Project: ..... Reiter Residence, 35 Pleasant St., Portland, ME

Date: ..... 14 September 2015

Re: ..... Response to Planning Dep't comments received 9/11/15

Memo To: Barbara Barhydt, Shukria Wiar  
From: David Margolis-Pineo  
RE: 35 Pleasant St. – Level II Site Plan Review 2010-138

**Wall & Roof Details**

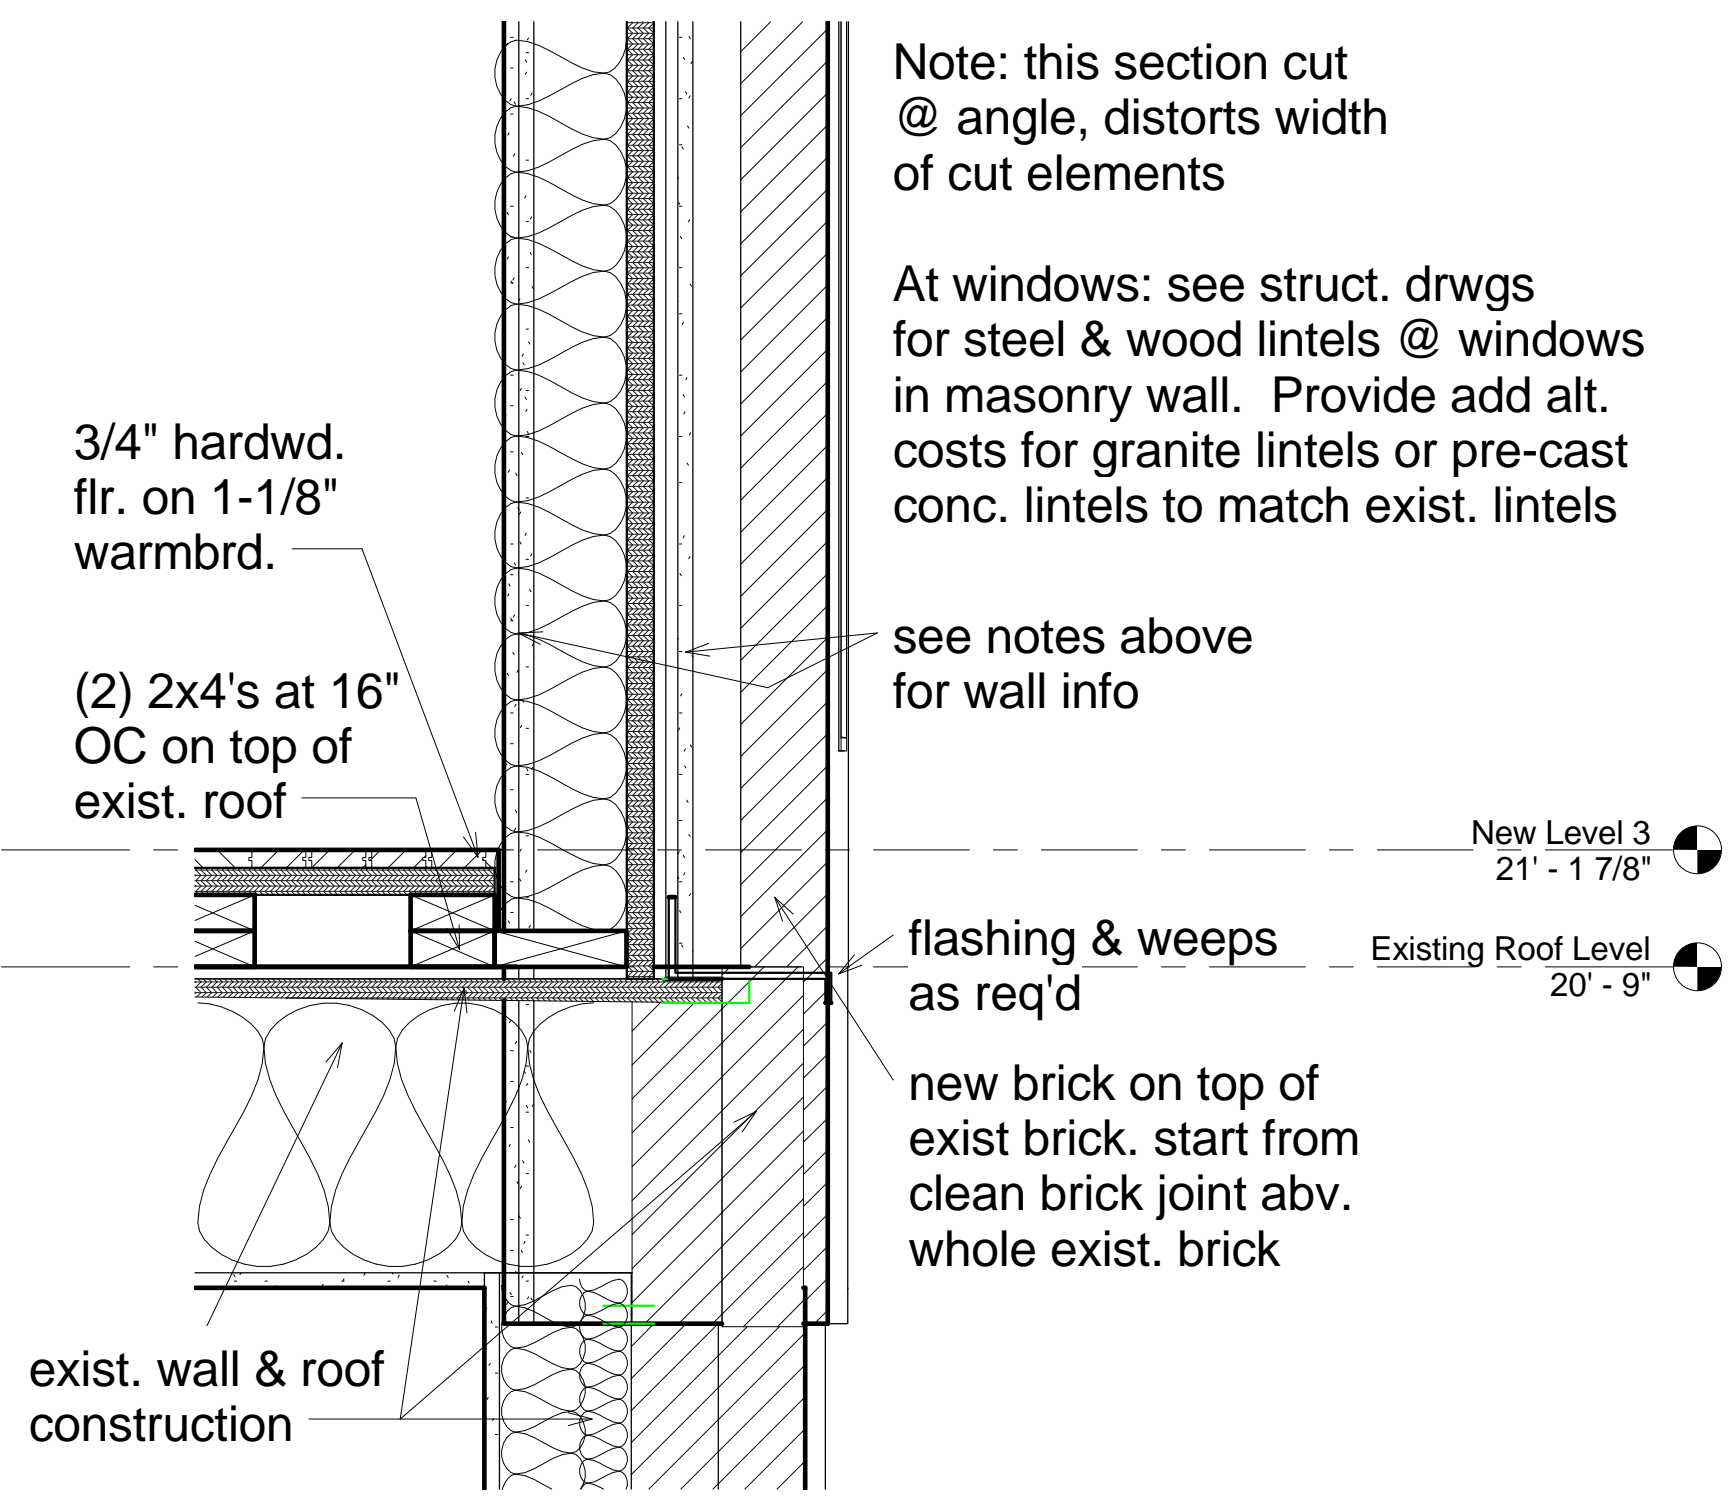
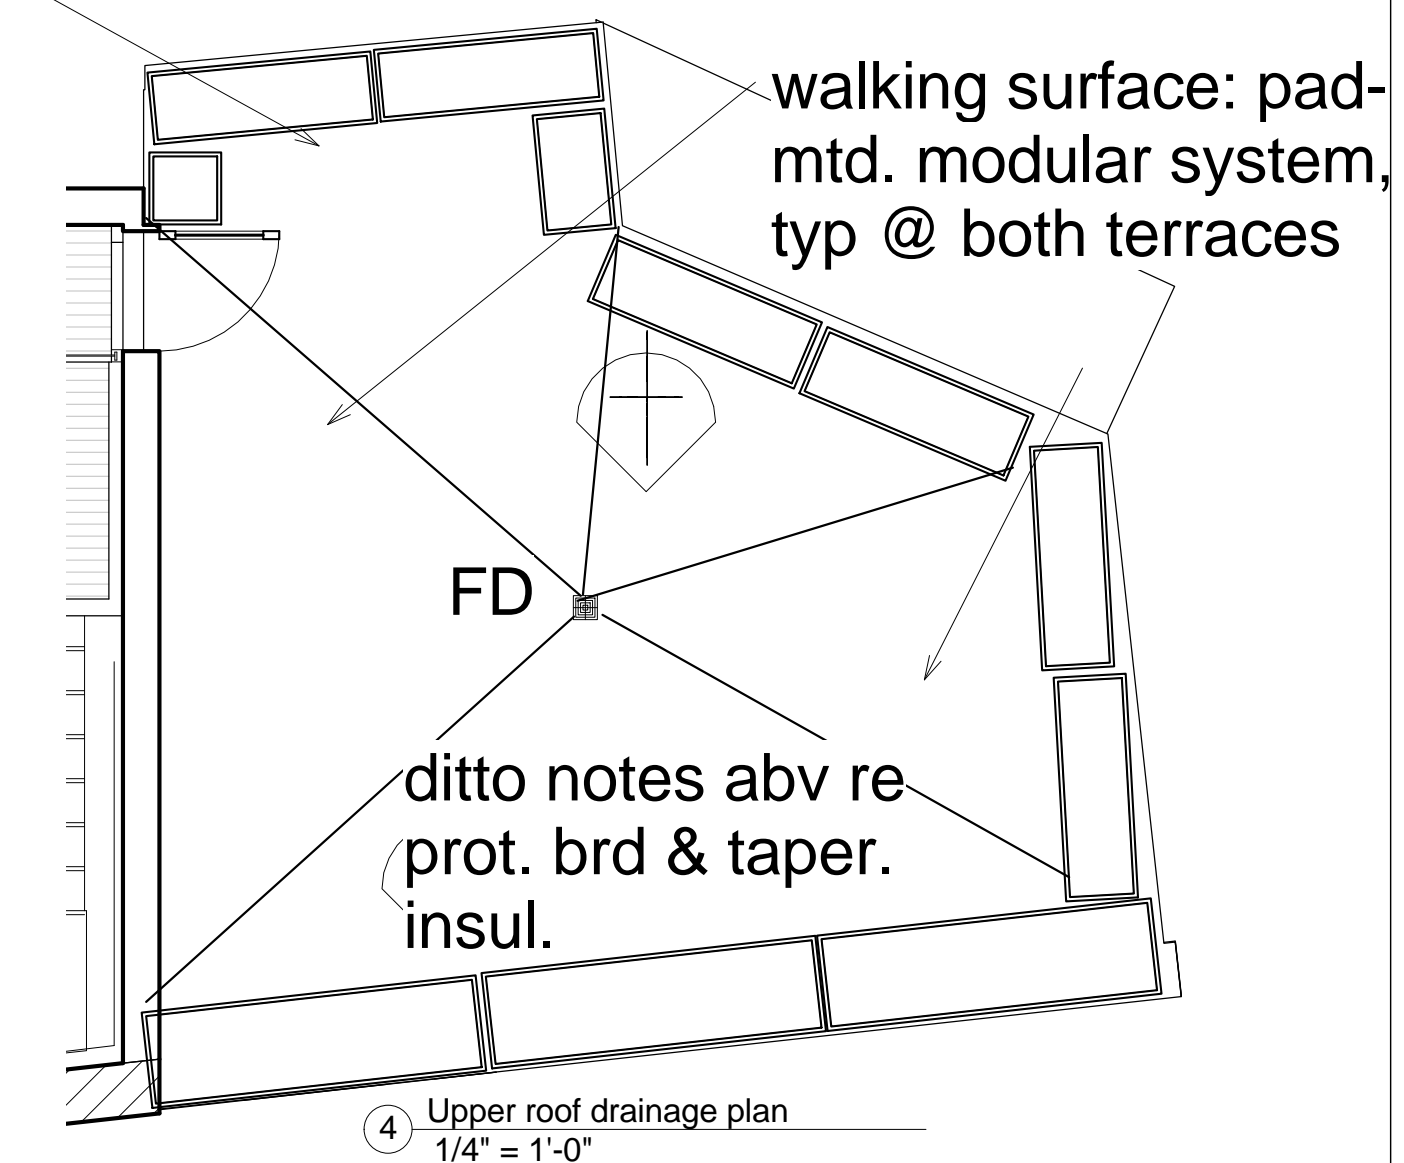
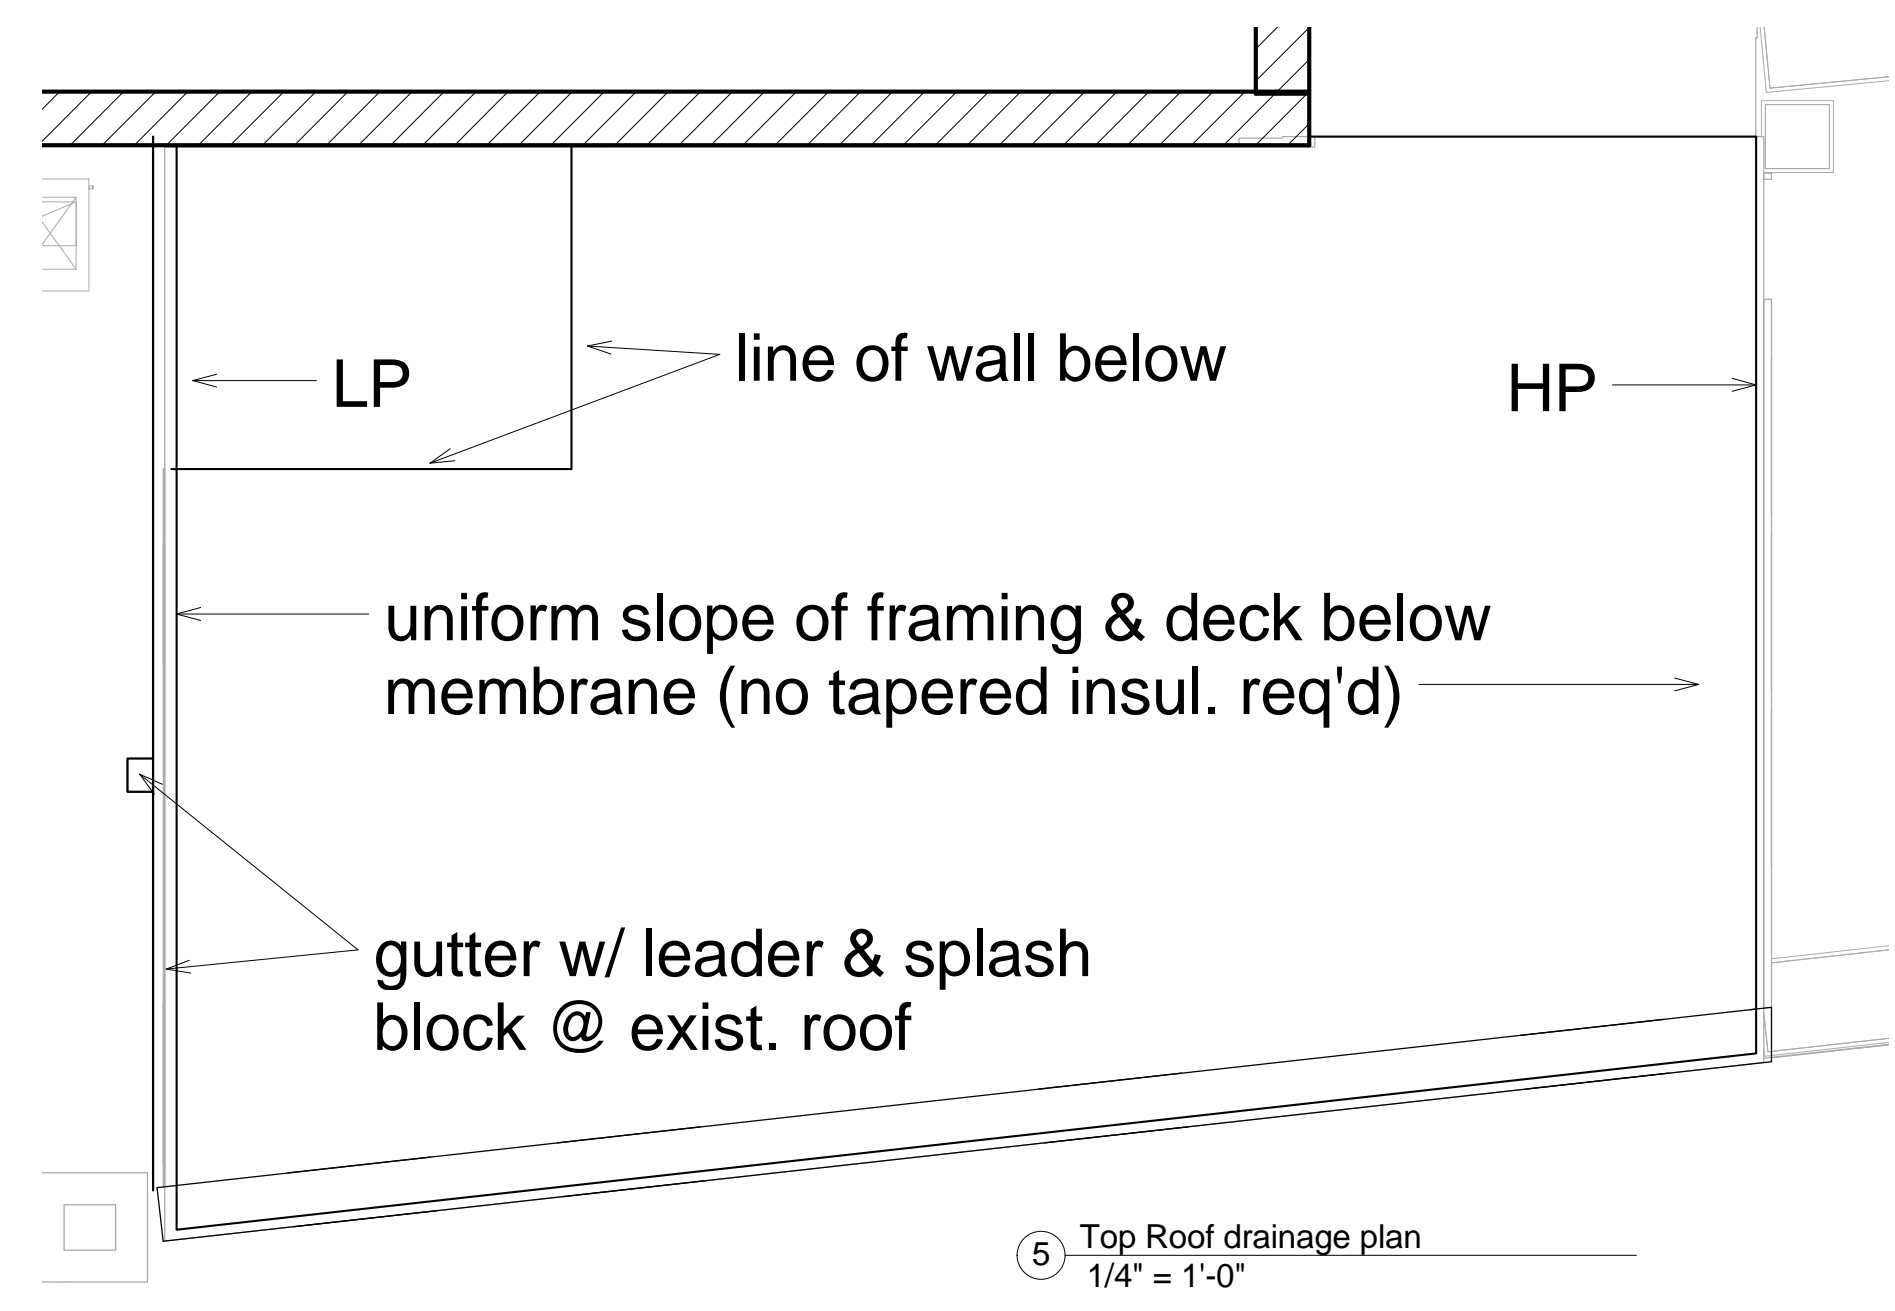
1) The Applicant has noted that an updated survey will be submitted showing topography in the parking area/area of the addition, and the location/elevation of a storm line connection point. If the proposed storm line is associated with roof water, the City DPS may prefer that the pipe discharge to the street in lieu of a direct connection to the combined sewer; the Applicant should verify through David Margolis-Pineo at the Department of Public Services. The Applicant should note that details will be necessary for all work within the Right-of-Way in accordance with the City of Portland Technical Manual (such as sidewalk repairs, pipe trench, etc).

*Please note that the updated survey was submitted 9/1/15 (and is reattached here). The proposed storm line connection was to pick up both roof stormwater as well as a foundation drain. Per discussion with David Margolis-Pineo today (9/14/15), the stormwater design has been re-directed to shed run-off directly to grade, rather than hard-piped to City storm system. This change has been made on the drawings - see Drawing A101, note #6, and Drawing A109, both revised 9/14/15. DM-P did note, however, that the foundation drain can be directly piped to the City system.*
